**City of Portland, Maine - Building or Use Permit Application**  
 389 Congress Street, 04101 Tel: (207) 874-8703, Fax: (207) 874-8716

<b>Permit No:</b> 04-1825	<b>Issue Date:</b>	<b>CBL:</b> 250 A018001
------------------------------	--------------------	----------------------------

<b>Past Use:</b> Single family home	<b>Proposed Use:</b> Single family home w/24'x28' 2 car detached single story garage	<b>Permit Fee:</b> \$147.00	<b>Cost of Work:</b> \$14,000.00	<b>CEO District:</b> 3
<b>Proposed Project Description:</b> Build 24'x28' 2 car detached single story garage		<b>FIRE DEPT:</b> <input type="checkbox"/> Approved <input type="checkbox"/> Denied	<b>INSPECTION:</b> Use Group: Type	
		Signature:	Signature:	
<b>PEDESTRIAN ACTIVITIES DISTRICT (P.A.D.)</b>				
Action: <input type="checkbox"/> Approved <input type="checkbox"/> Approved w/Condition <input type="checkbox"/> Denied				
		Signature:	Date:

STRUCTURAL DETAILS @ RIGHT ELEVATION

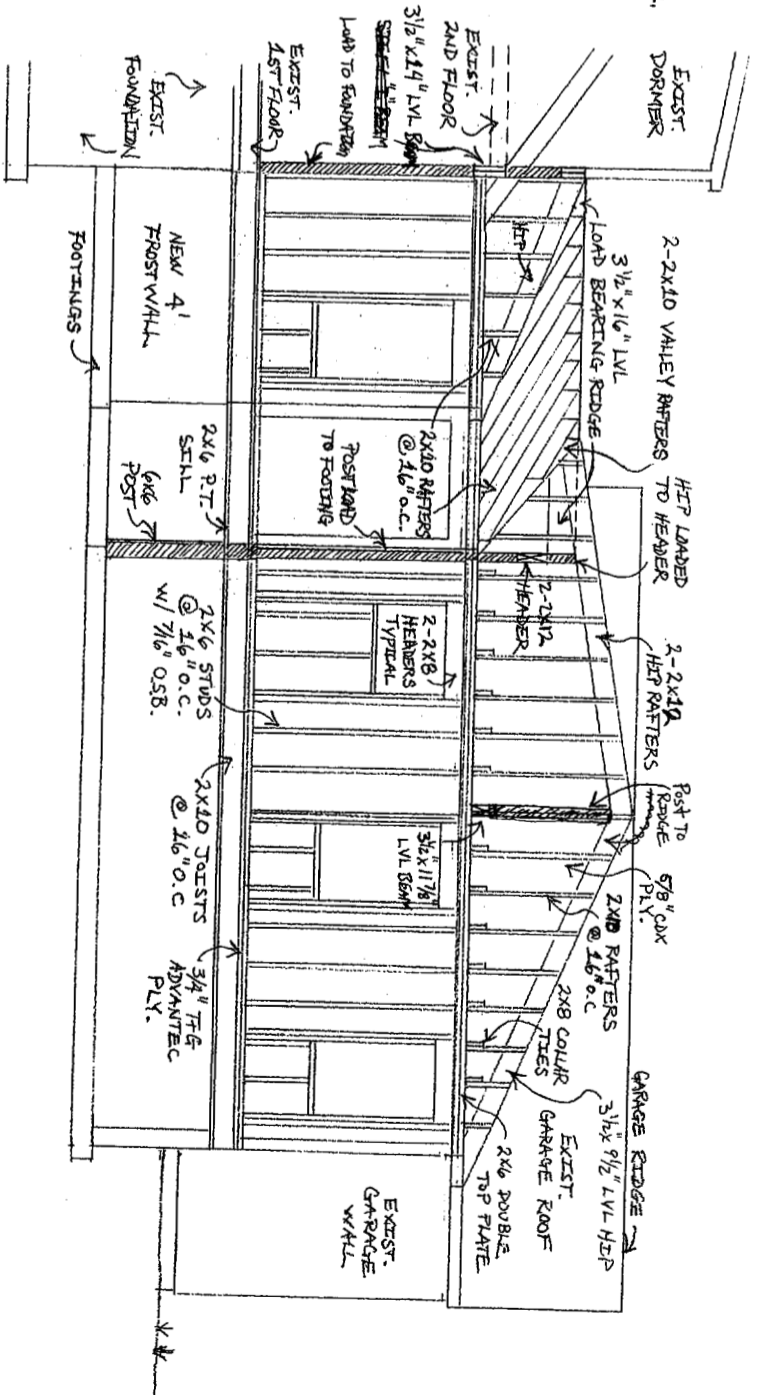
<b>Comments:</b>
1/7/05-tmm: need to add frost wall - spoke w/builder he will get back to me
3/8/05-tmm: rec'd frost wll apln - ok to issue
